10 November 2011

**RE: MP 10_0027 – Stages 2 & 3, 1 Australia Avenue Sydney Olympic Park
Response to SOPA letter**

SOPA wrote to the Department of Planning & Infrastructure on 17 October 2011 raising additional issues in response to the Preferred Project Report. Each of the issues raised by SOPA are addressed below.

1 East Elevation
1:250

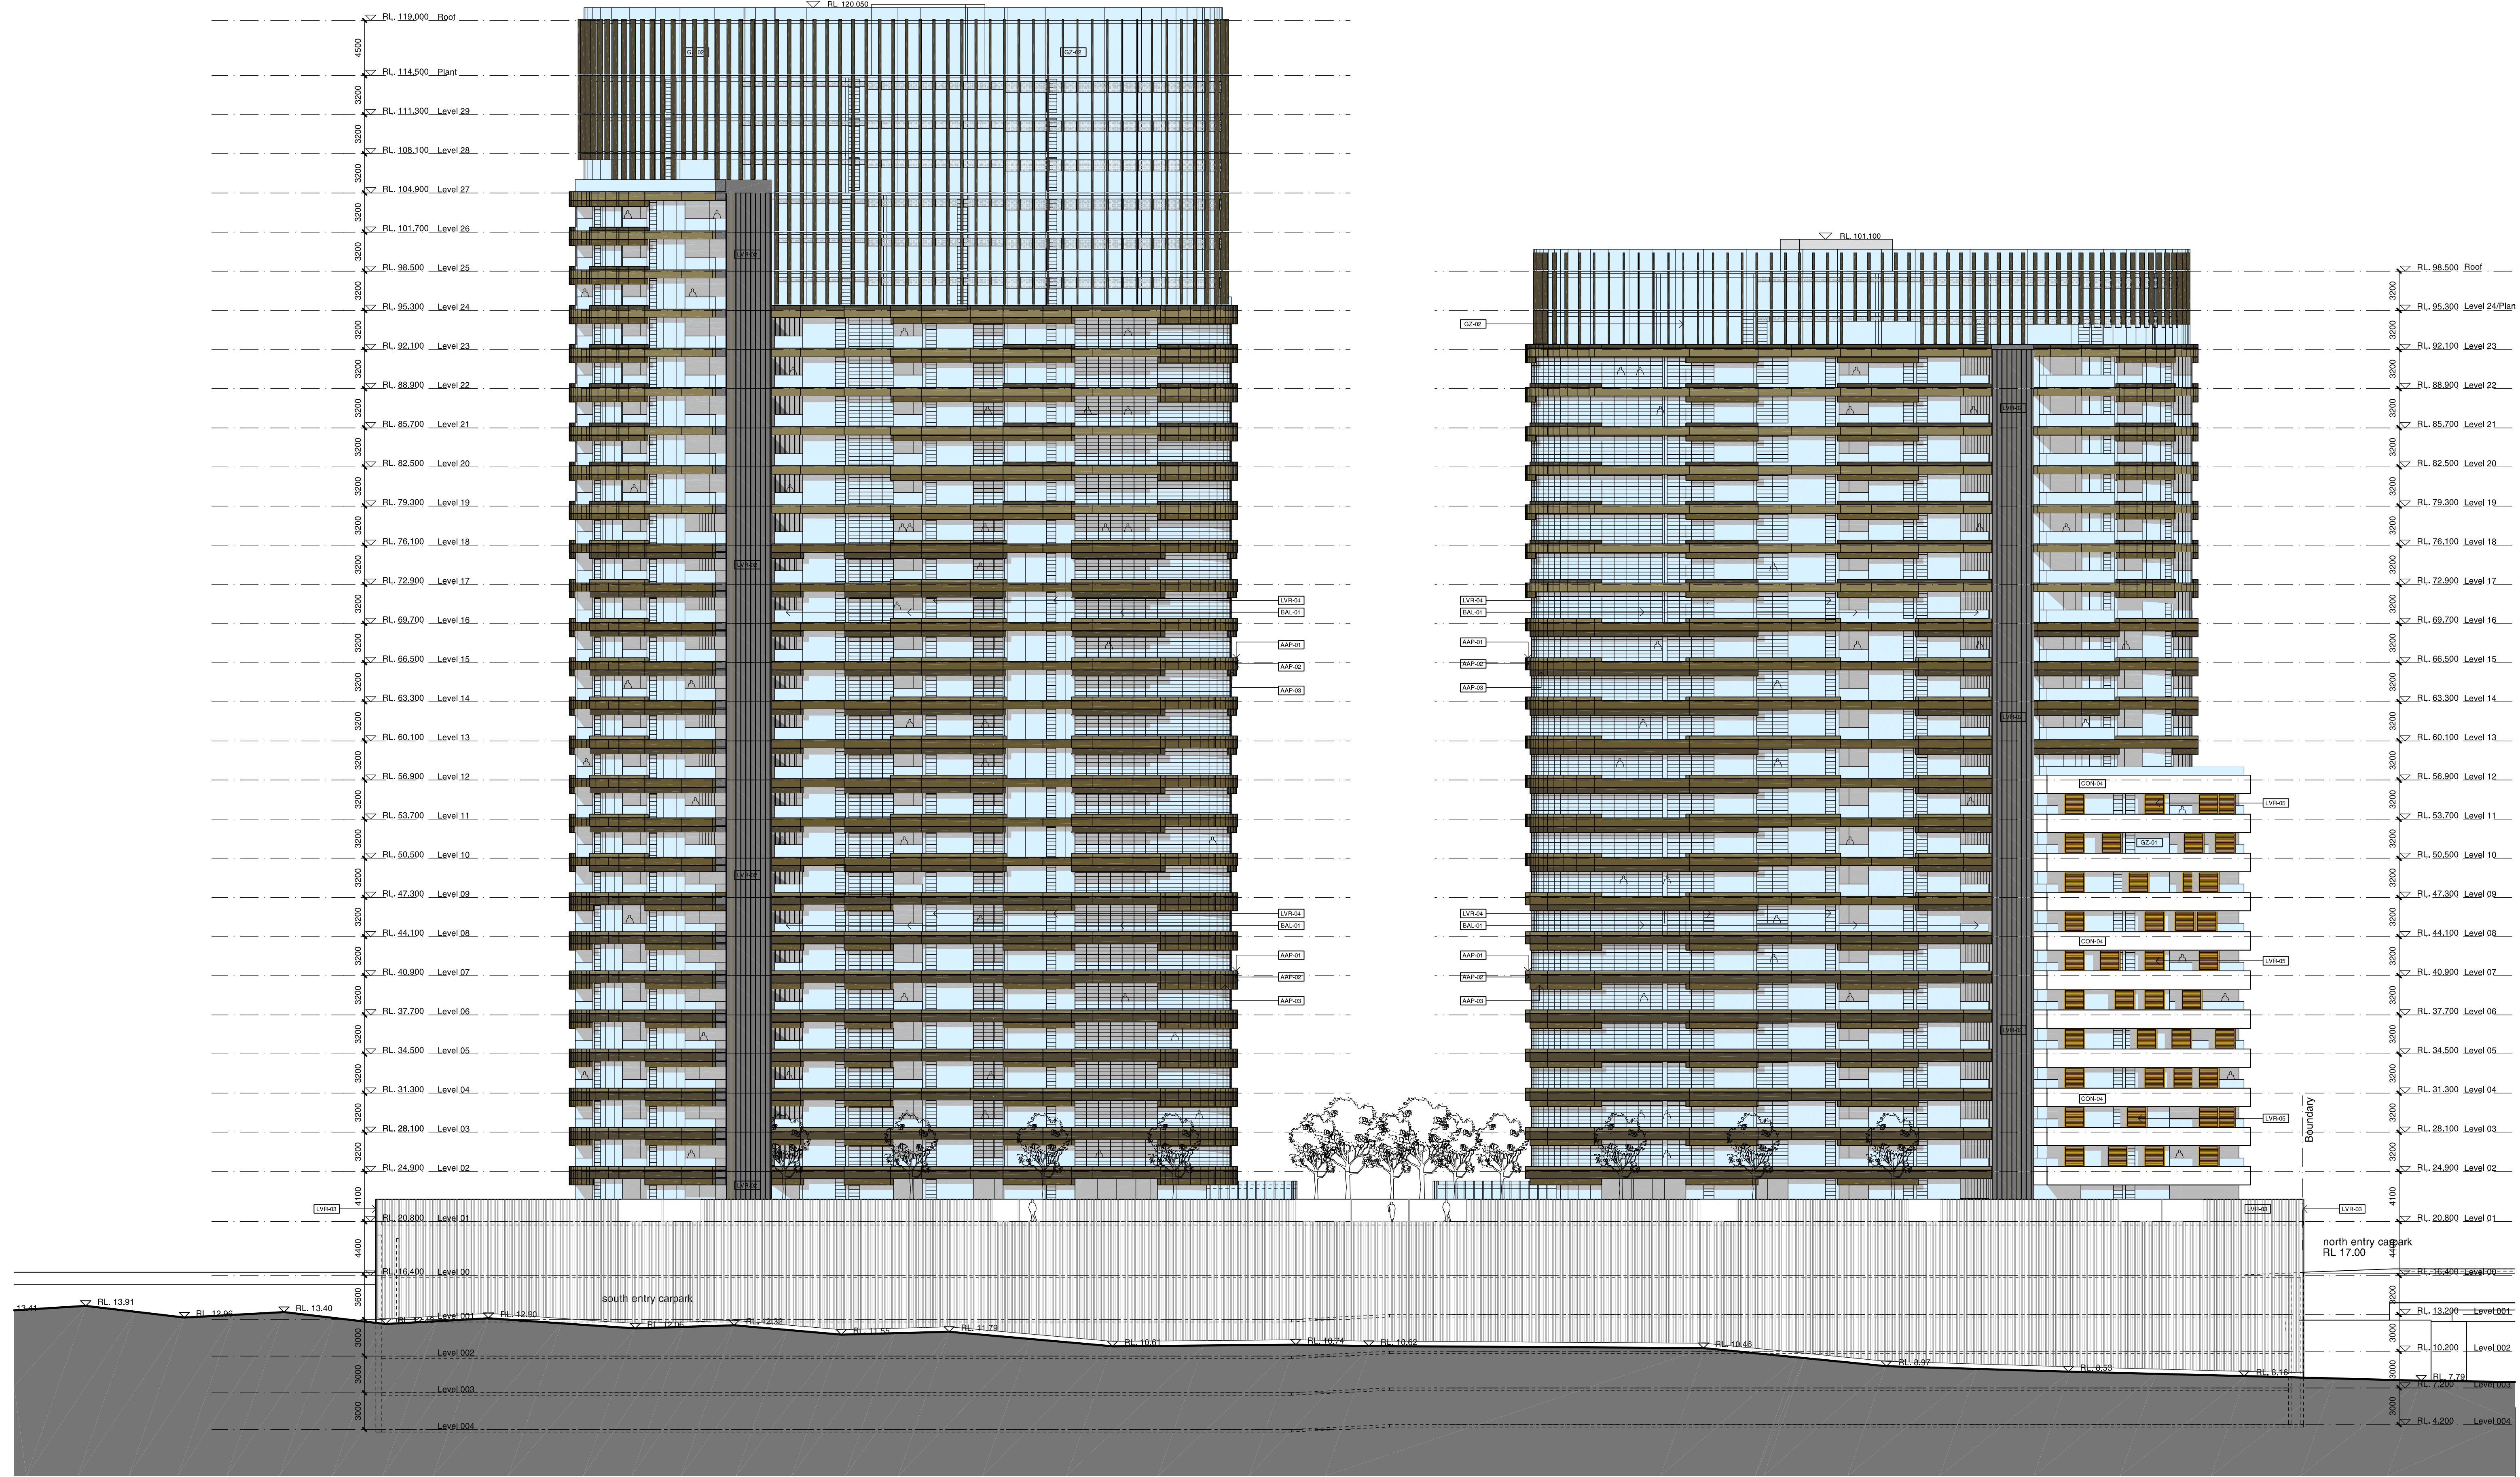
Clarification is sought by SOPA on the proposed material and finish of the eastern elevation of the podium and requests this be consistent with the Stage 1 development.

Bates Smart have provided an elevation and plan as well as an image of a precedent for the eastern elevation facing the railway line at **Attachment B**. Bates Smart state that the elevation is to be clad in steel Z-purlins with a clear galvanised finish.

The proposed metal finish is compatible with the adjacent elevation of the Stage 1 building which has a metal cladding with a neutral finish.

Scale
1:200@A1, 1:400@A3
Drawn
Project No.
S11202
Status
DA
Plot Date
8/11/2011 2:42:00 PM
Plot File
\\LIV\DC-01\Sydney\Site Drive - Oxford St\11200-11299\11202_J...
Drawing No.
DA02.224[D]

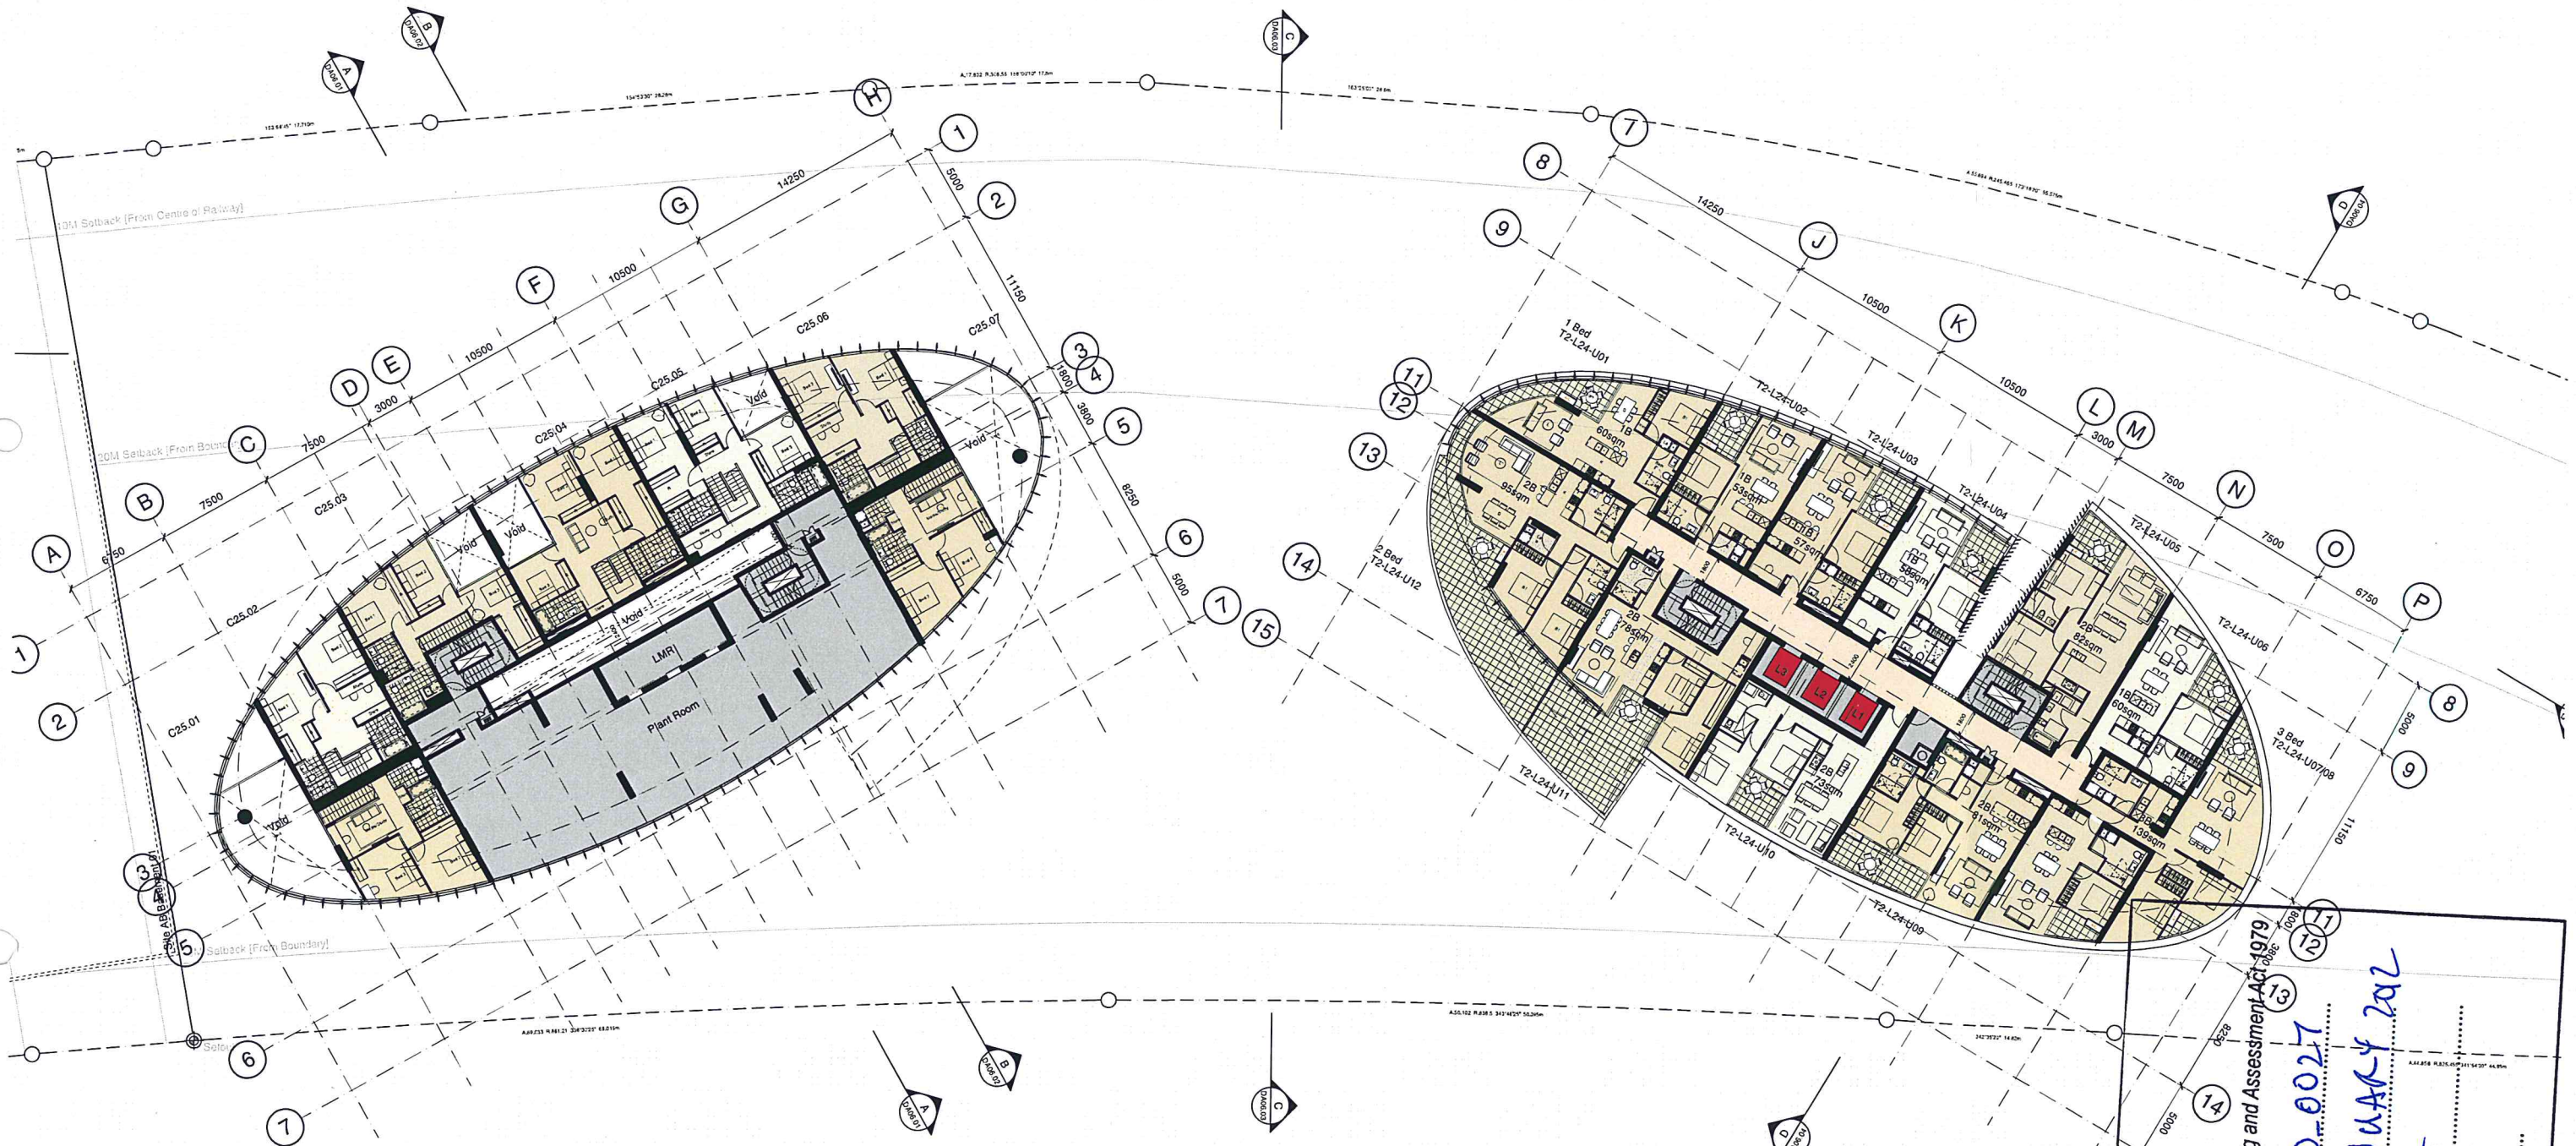
SOPA suggest that the 3 bedroom units on Levels 23 to 26 in Tower 2 could be converted into separate 1 bedroom and 2 bedroom units. SOPA request an explanation of this unit arrangement.

The 3 bedroom units at levels 23 to 26 are proposed as two storey apartments. These units add to the variety of units types proposed and provide for housing choice and diversity and supports the objectives of the SOPA Master Plan 2030. Any modifications to the unit mix would be subject to a separate assessment under Section 75W of the Environmental Planning and Assessment Act 1979.
